STATEMENT OF GORDON J AHALT IN OPPOSITION TO THE GRANTING OF A REASONABLE USE EXCEPTION IN CASE CA015-001 & VARIANCE18-002 - May 20, 2020

RE: GEOTECHNICAL THIRD-PARTY REVIEW, 5637 EAST MERCER WAY,
CITY OF MERCER ISLAND PROJECT NO. CAO15-001

A PORTION OF GOVERNMENT LOT 3, OF SECTION 19, TOWNSHIP 24 NORTH, RANGE 5 EAST, W.M., KING COUNTY, WASHINGTON

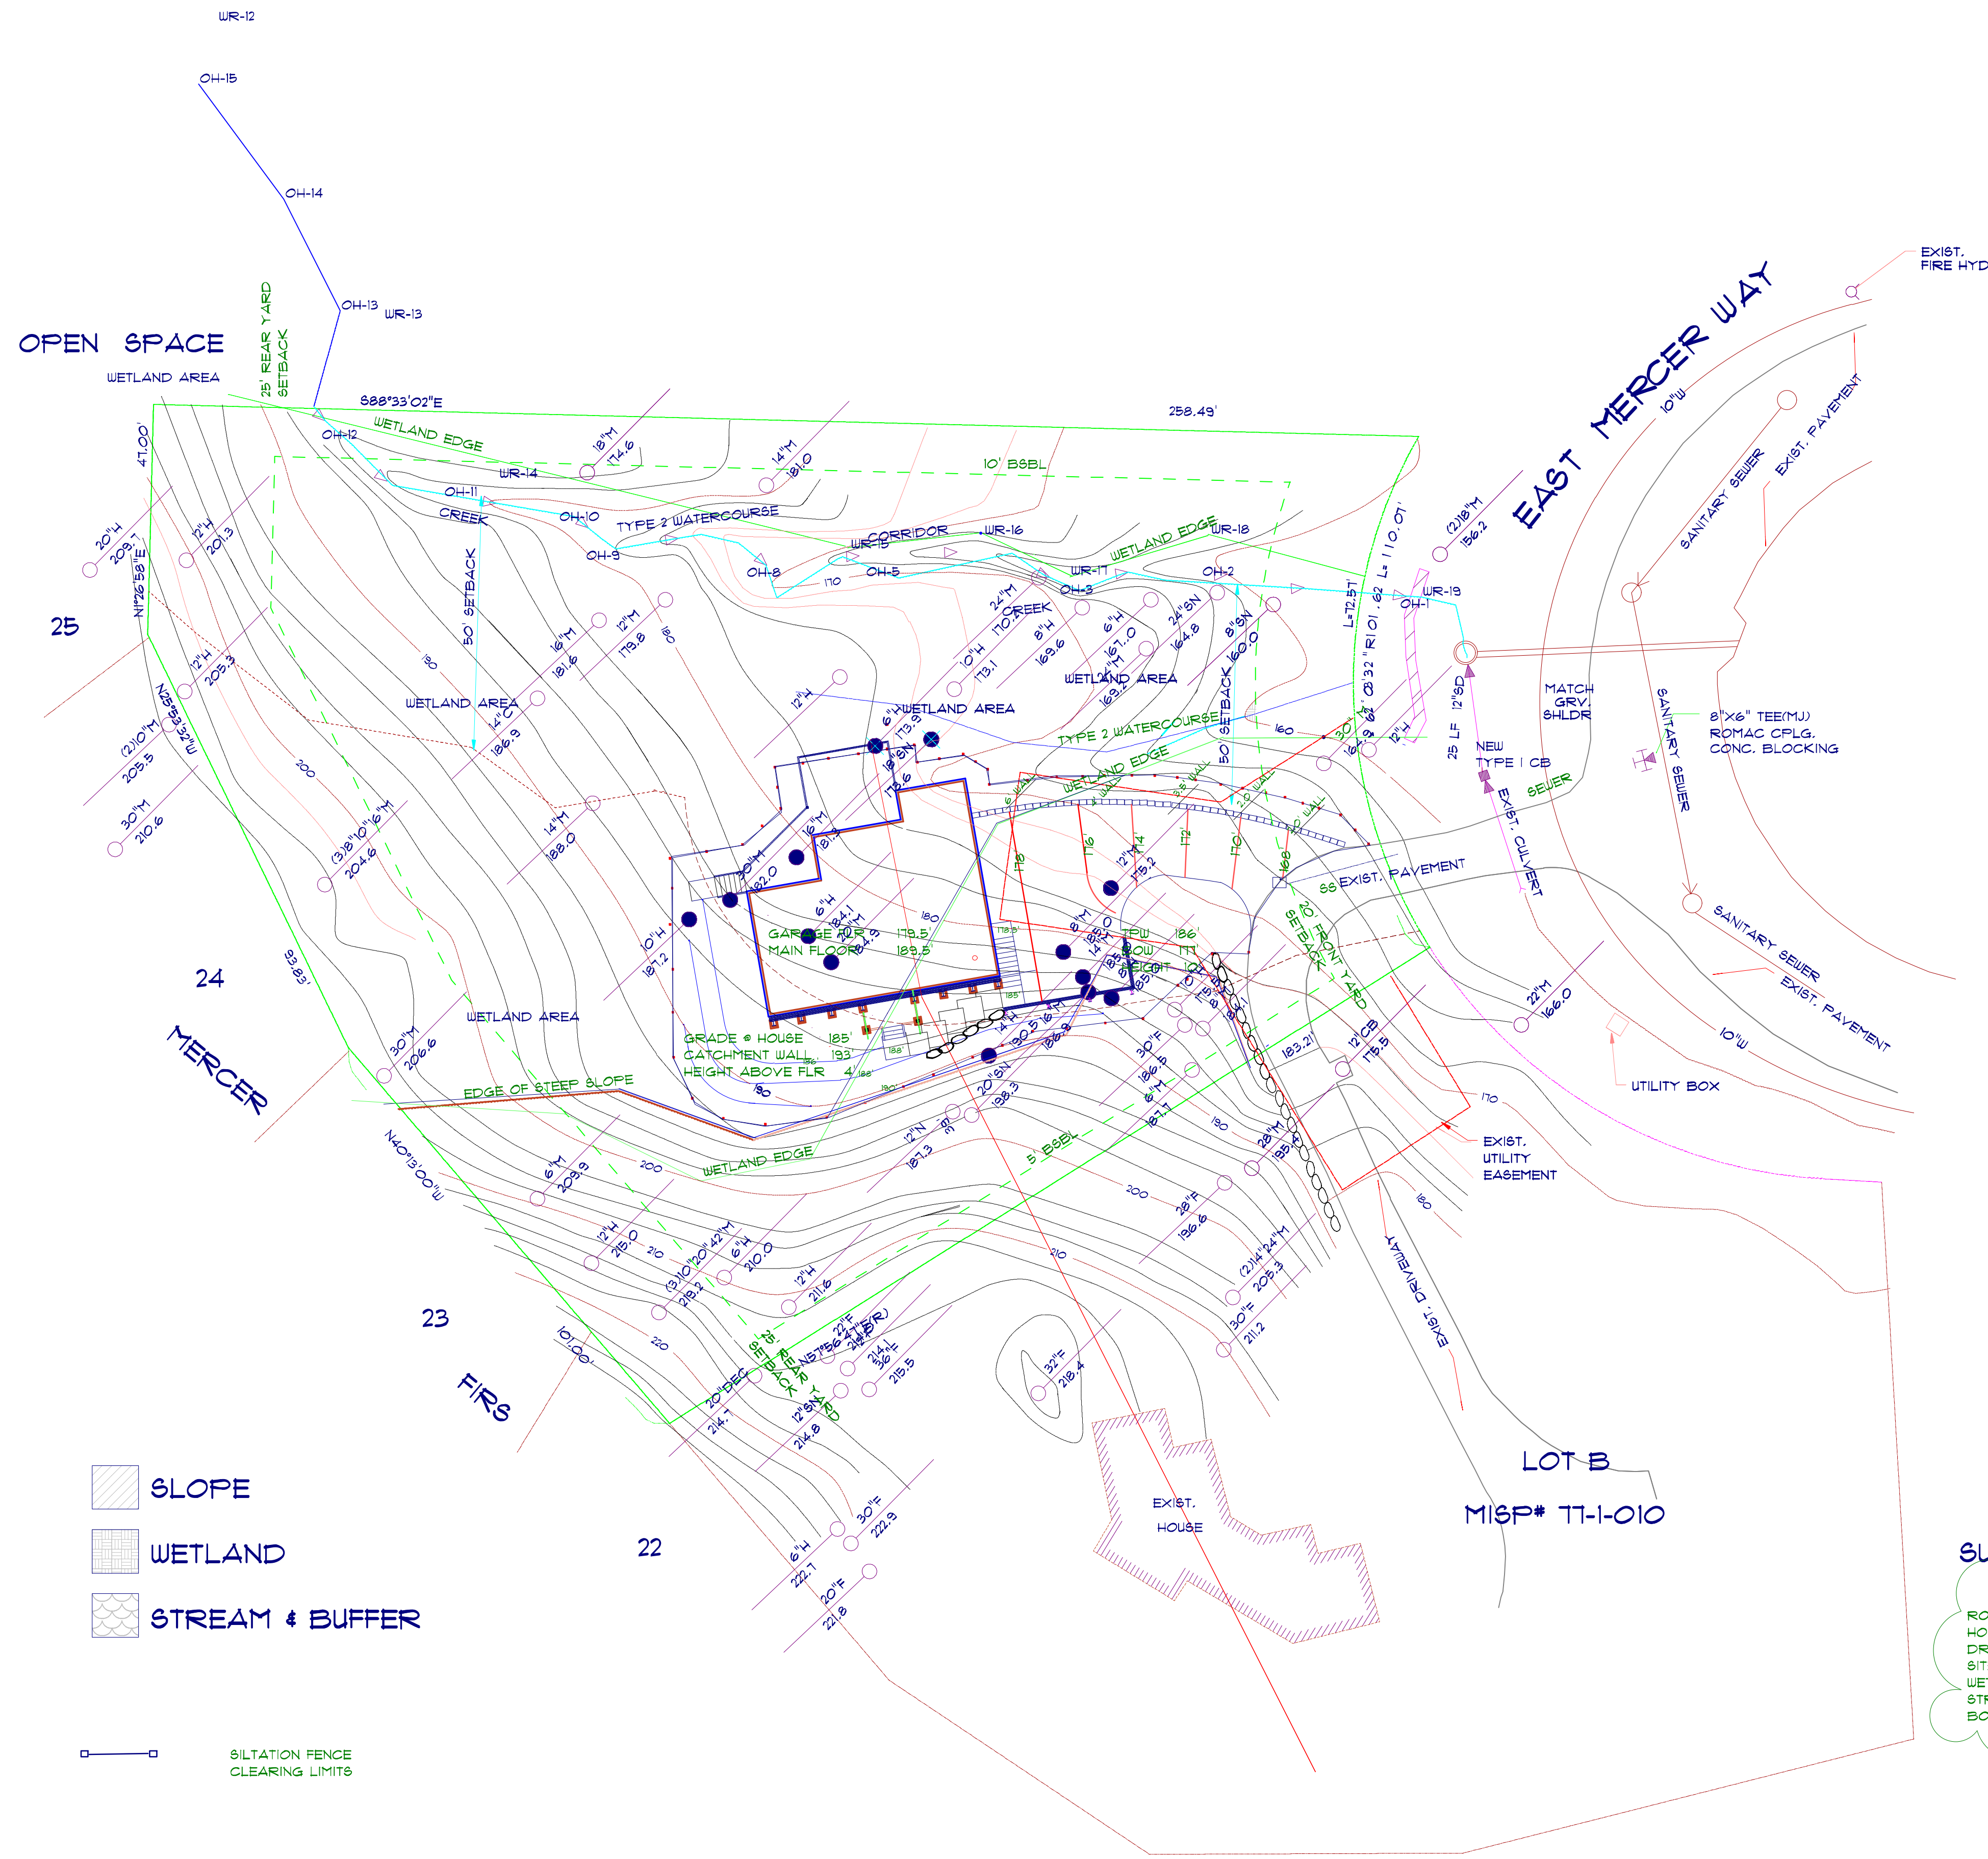
- 2) The site plan for the property by Healey-Jorgensen dated May 25, 2018 (attached as Ex. AH-2) depicts the location of the southern Type 2 Watercourse, which originates in the center of the wetland, approximately 25’ further north than the Healey-Jorgensen site plan dated Oct. 17, 2016 (attached as Ex. AH-3). An enlargement of the May 25, 2018 site plan (attached as Ex. AH-4) makes it easier to see the location of the southern stream depicted in this site plan. The May 25, 2018 site plan is the proposed site plan by the Applicant today.

Attached is Ex. AH-5 which is an enlargement of the site topo and site plan where I have highlighted in yellow the southern Type 2 Watercourse depicted by Healey-Jorgensen in the May 25, 2018 site plan (Ex. AH-2), and I highlighted in green where Healey-Jorgensen depicted the location of the southern Type 2 Watercourse in the Oct. 17, 2016 site plan (Ex. AH-3) and where it was depicted in prior site plans until the change in May 25, 2018. Note that the yellow location further north and away from the proposed house does not follow the V in the contour lines depicting the lowest elevation points but rather has the stream flowing at a higher elevation along a ridgeline that separates the northern and southern Type 2 Watercourses. The green hash line shows the location of the southern Type 2 Watercourse as depicted in Healey-Jorgensen site plans up to and prior to their Oct. 17, 2016 site plan (Ex. AH-3).

Therefore, it appears the southern Type 2 Watercourse depiction in the May 25, 2018 site plan (Ex. AH-2) was done without the benefit of a survey to confirm the actual location. This conclusion is further supported by the email from Michael Moody dated May 22, 2018 (Ex. AH-8) where he concludes it is better for Core Design to do a new survey rather than use the CHS survey because of inaccuracies he sees in the CHS survey. Clearly Core Design did not do a new survey before the Healey-Jorgensen May 25, 2018 site plan was completed as Core Design did not have the prior CHS files until May 31, 2018.

A visual inspection of the property will show that the southern Type 2 Watercourse is not accurately depicted in the most recent Healey-Jorgensen site plan because it is easy to see that the stream does not flow down the middle of the ridgeline that separates the northern and southern Type 2 Watercourses, and also because the most recent site plan shows the southern Type 2 Watercourse on the north side of two large trees, whereas, the site plans up to and prior to May 25, 2018 show the southern Type 2 Watercourse on the south side of the same two large trees. This can be seen in Ex. AH-2, Ex. AH-3, and Ex. AH-5.

A visual site inspection will also show any observer that the gross area of the Category III Wetland depicted in the Healey & Jorgensen site plan is grossly understated. The site plan excludes a large area of the wetland on the southeast side of the property where it adjoins the Stivelman property. The applicant represents that the southeast corner, representing approximately 245sf, will not be in the wetland and that this is a significant reduction of intrusion in the wetland from the prior site plan. The reality is the wetland border is not accurate and 100% of the proposed house foundation will be in an existing wetland where there is running surface water coming out of the steeply sloped hillside from Stivelman's property. I would also argue that a 245sf reduction in the wetland intrusion by the proposed home is not a significant reduction.

The Healey-Jorgensen site plan contains a lot of inaccuracies. Topo lines are inaccurate as stated by Core Design, the southern Type 2 Watercourse has been arbitrarily depicted without a survey, the area of the Category III Wetland has been inaccurately depicted and reduced in size from prior site plans submitted to the City, and this is a very dynamic site where trees fall every year, directional water flows migrate and change, and there is continual siltation of the Ravine from upstream waterflows.
